The Secretary
NSW Department of Planning, Industry & Environment

28 July 2022

I refer to the Department's email of 20 July 2022 regarding the exhibition of the Environmental Impact Statement (EIS), for State Significant Development SSD-30240120 Wollongong Private Hospital Expansion for 'Demolition of non-hospital buildings and erection of a nine-storey hospital extension with basement carpark, comprising 191 additional beds, emergency department, expansion of operating theatres, radiology and intensive care units and landscaping' at 15, 17, 19 and 21 Urunga Parade and 360, 366 and 368 Crown Street, Wollongong (Lot D DP 402234, Lots 9 & 47 DP 5507, Lot CP and 1-4 SP 73256, Lots A & B DP 343680, Lot 2 DP 1212956) in the Wollongong City Council Local Government Area (LGA). Submissions need to be made to the Department by 18 August 2022.

Figure 2.4 - Existing Underground Endeavour Energy Network and Indicative New Substation Location

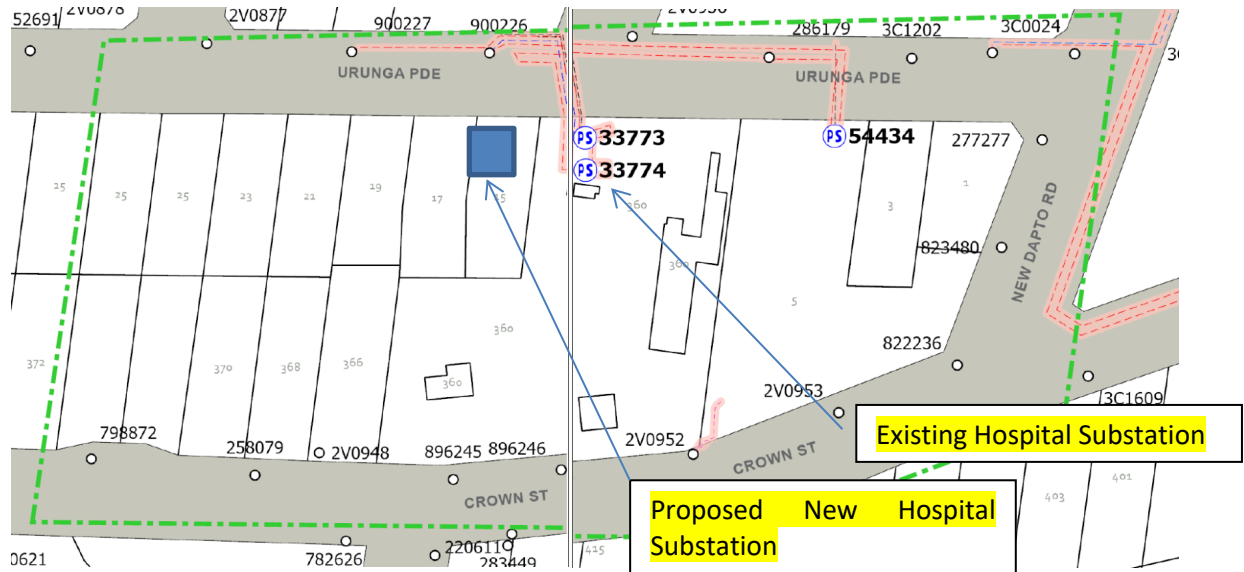
The 'Proposed New Hospital Substation' does not appear to be shown in the Architectural Plans. As shown in the following Clause 5.3.5 'Indoor substations', from Endeavour Energy's Mains Design Instruction MDI 0044 'Easements and Property Tenure Rights', indoor substations require the following:

5.3.5 Indoor substations

The boundaries of an easement for indoor substation must be defined by the internal face of the walls, ceiling, floor, and cable trenches of the substation room.

An easement for the cables that enter and exit the substation room will also be required if they are not installed within public roads and/or existing Endeavour Energy easements.

A right of access may also be required to give Endeavour Energy employees, vehicles, and equipment unrestricted access to the indoor substation at all times.

Generally it is the Level 3 Accredited Service Provider's (ASP) responsibility (engaged by the developer) to make sure substation location and design complies with Endeavour Energy's standards the suitability of access, safety clearances, fire ratings, flooding etc.
